PORTLAND MAINE

May 19, 2010

CBL: 177 I004001
Located at 215 STEVENS AVE

Inspection Violations

REPAIRS TO IVY ST. GARAGE
AS DISCUSSED WITH NICK ADAMS

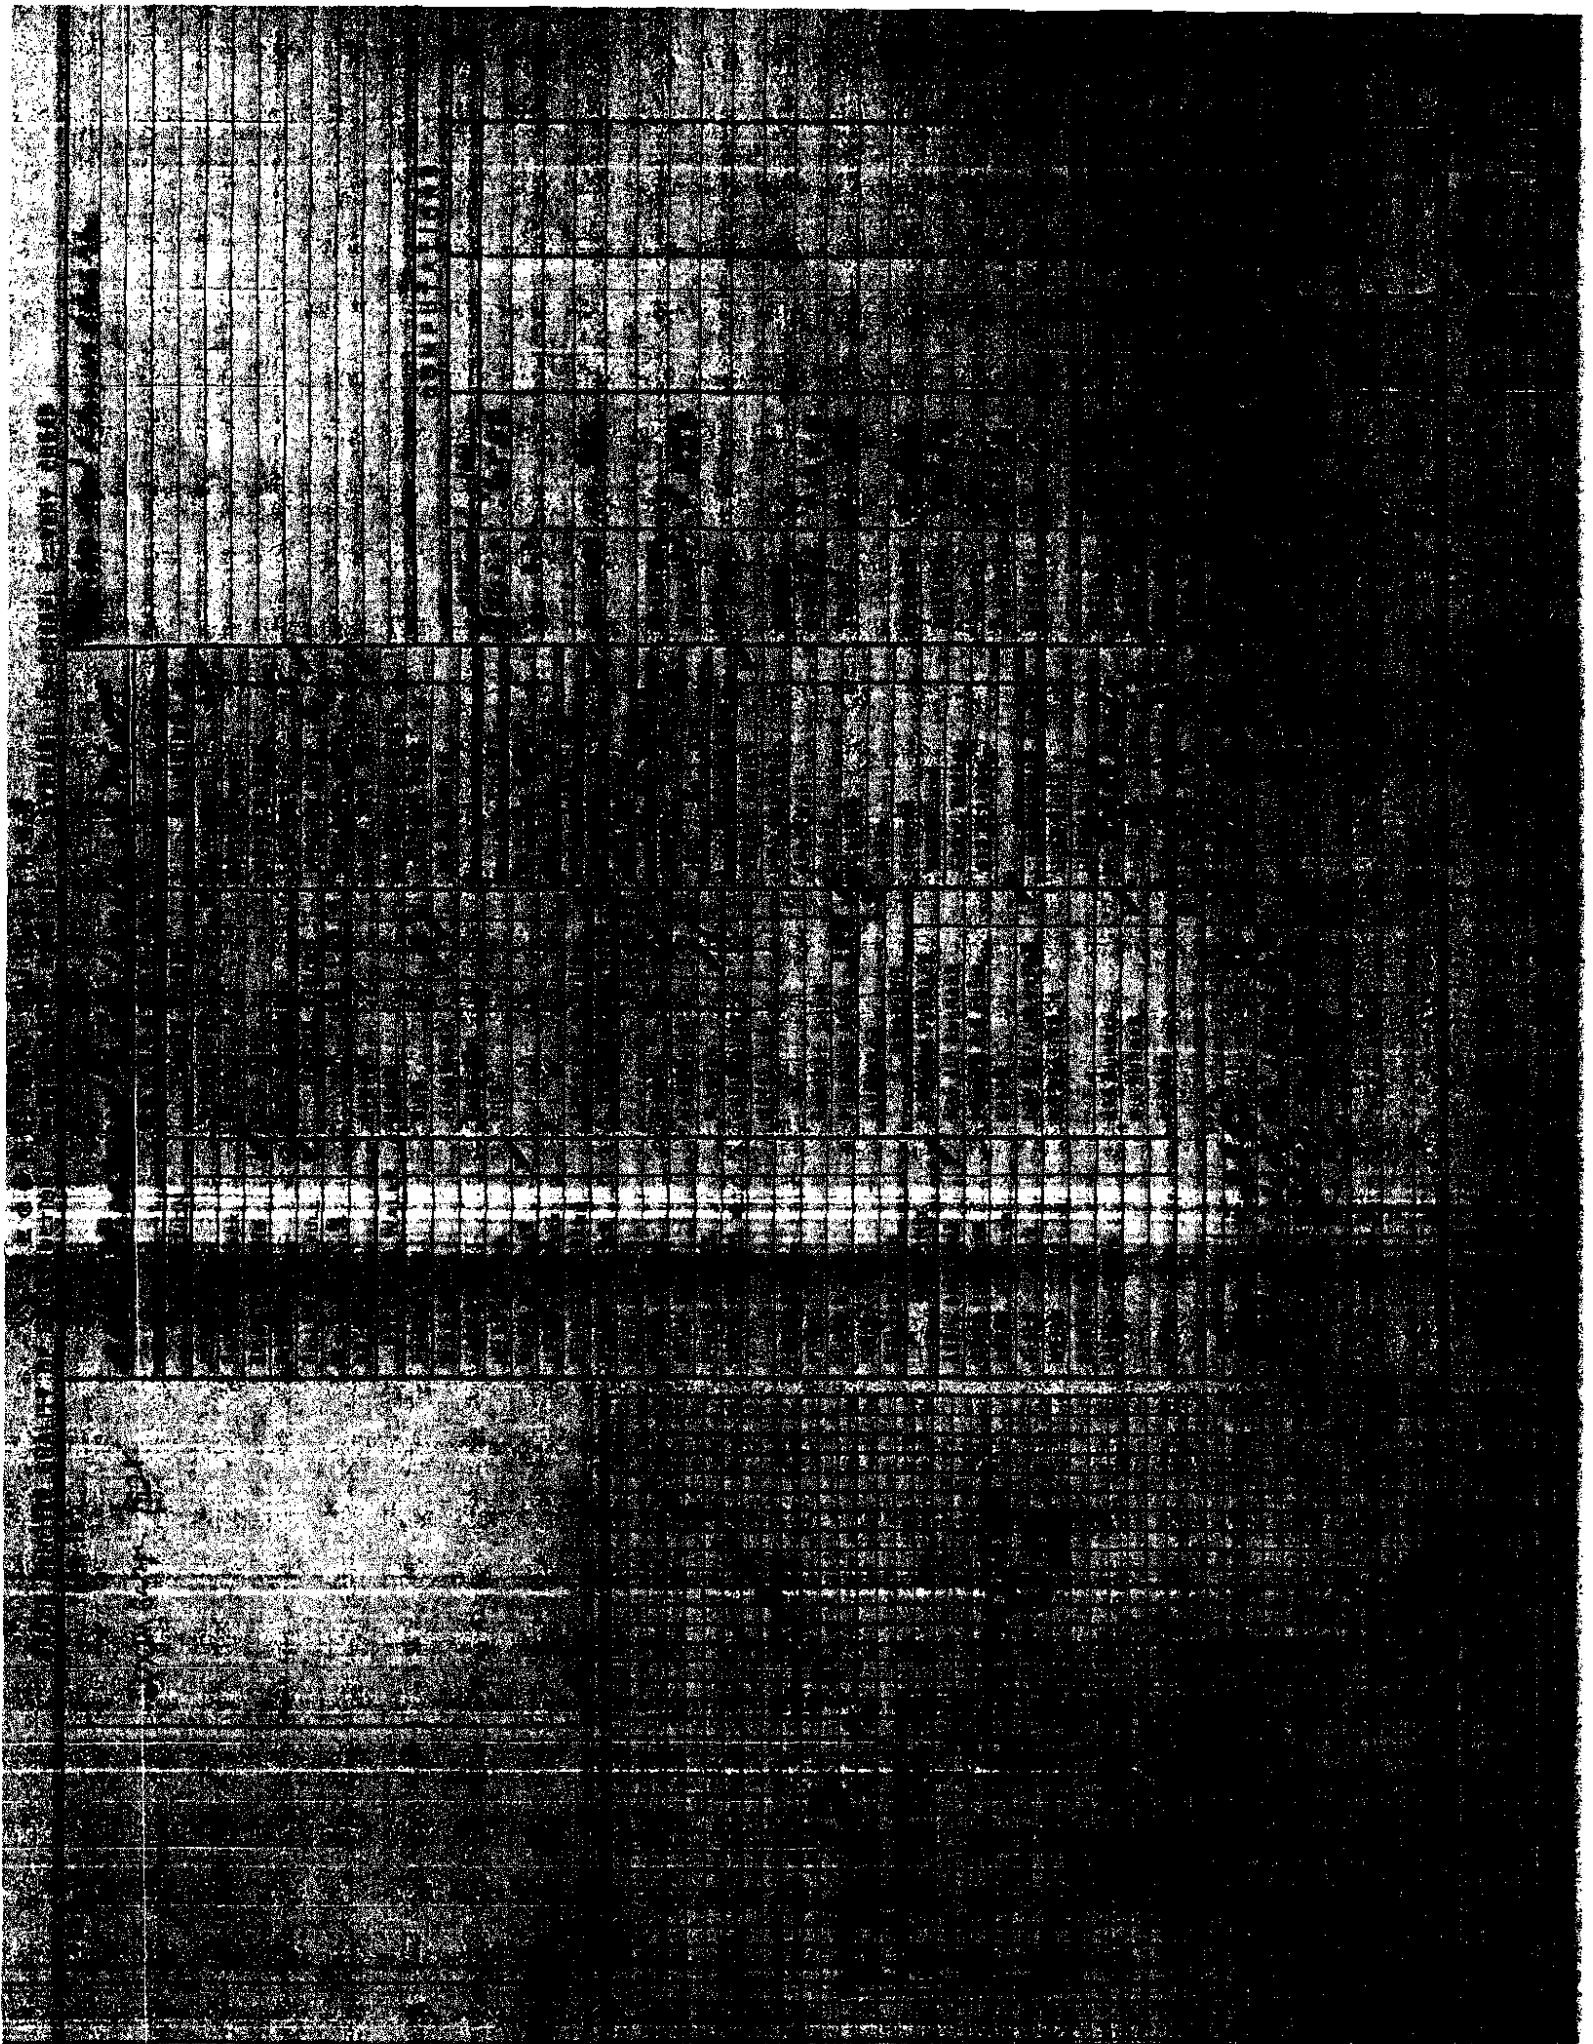
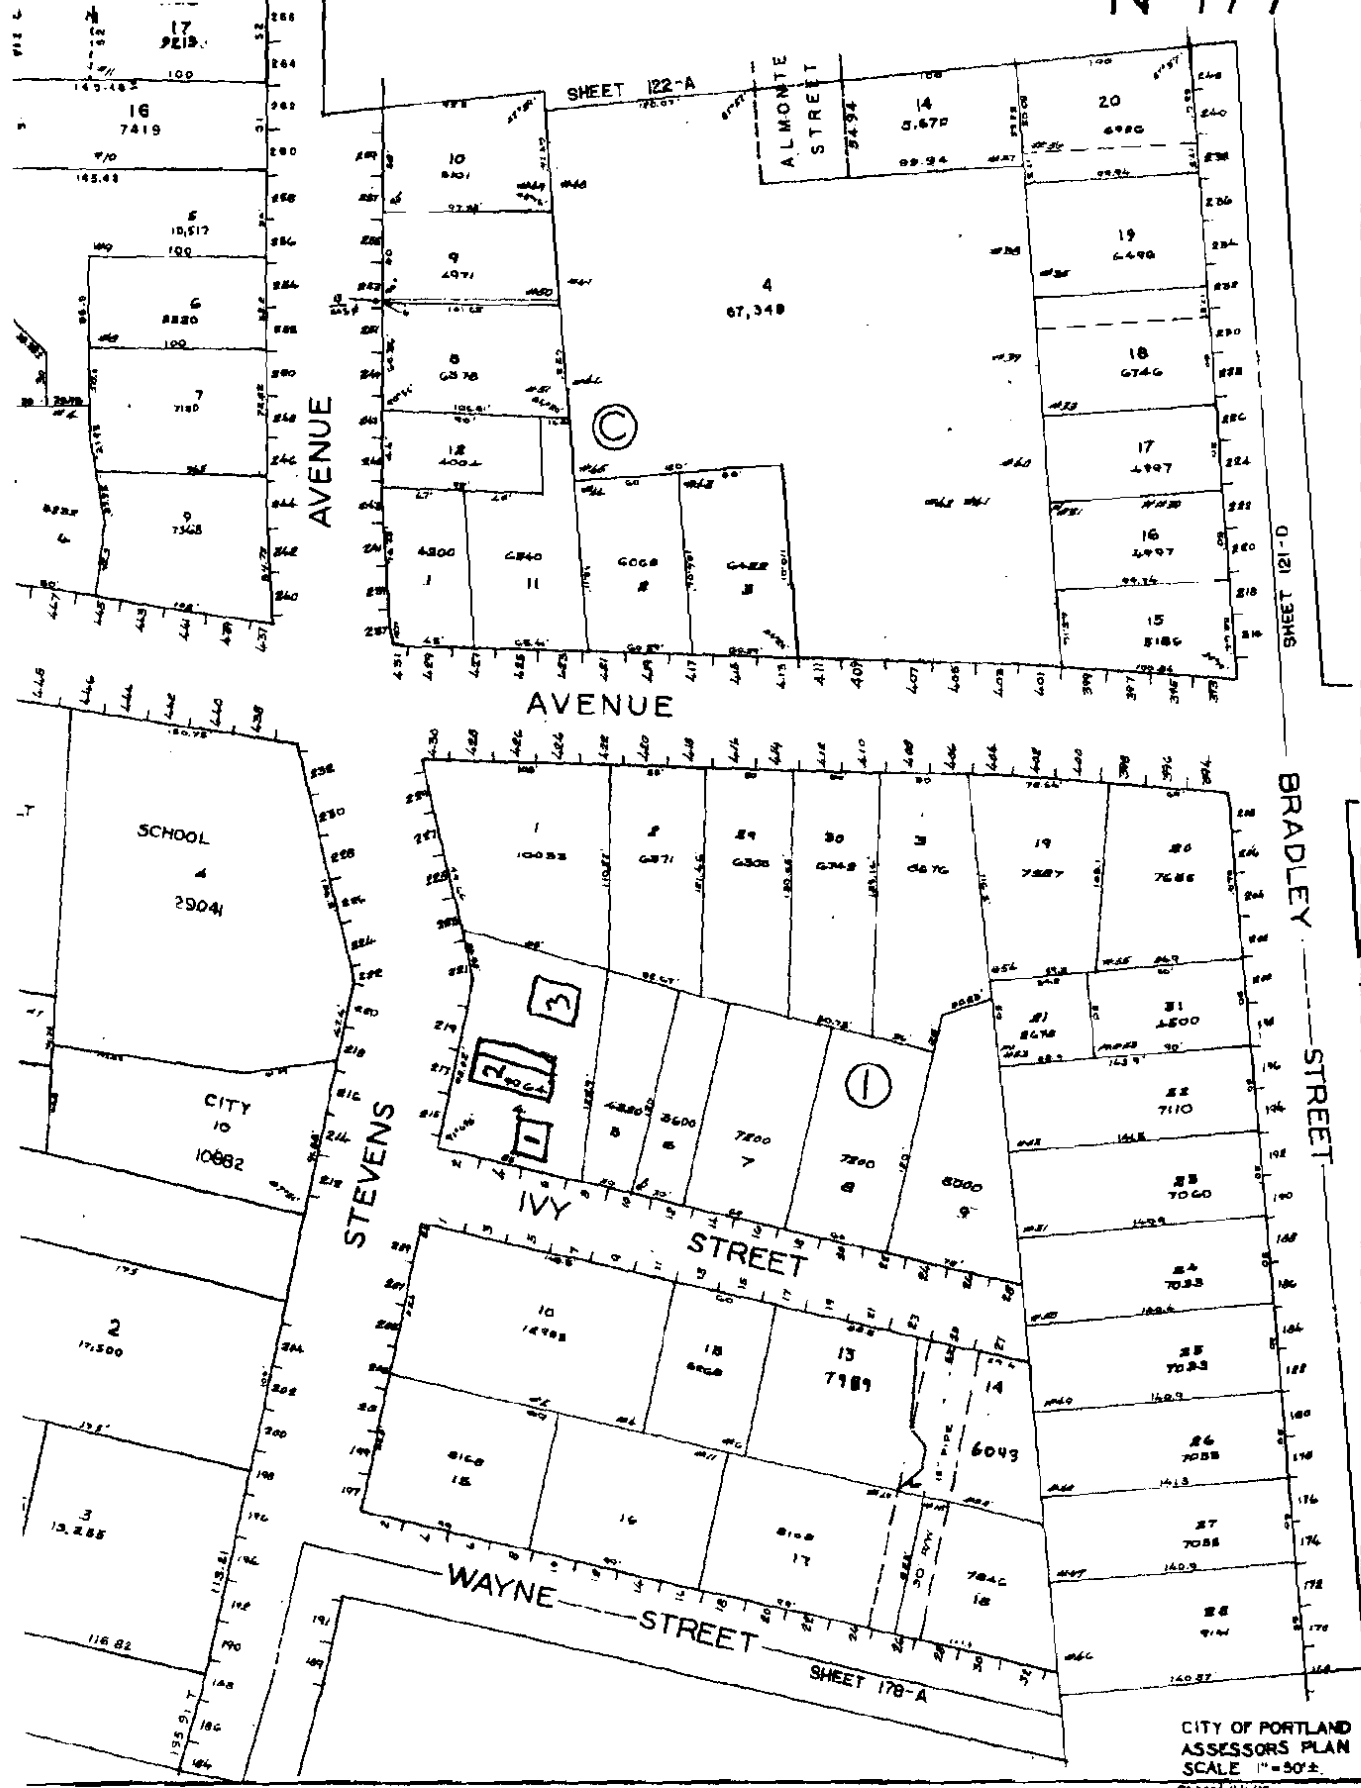
Code	Int/Ext	Floor	Unit No.	Area	Compliance Date
1) 6-108.(a)	Exterior			Garage	
Violation:	Foundations cellars, exterior walls, roofs				
Notes:	On the Ivy st side of the property there is a garage that is falling down this building needs to be fixed up ASAP NLA

Comments: Garage is in dire need of repair or demo needs to be taken care of ASAP NLA
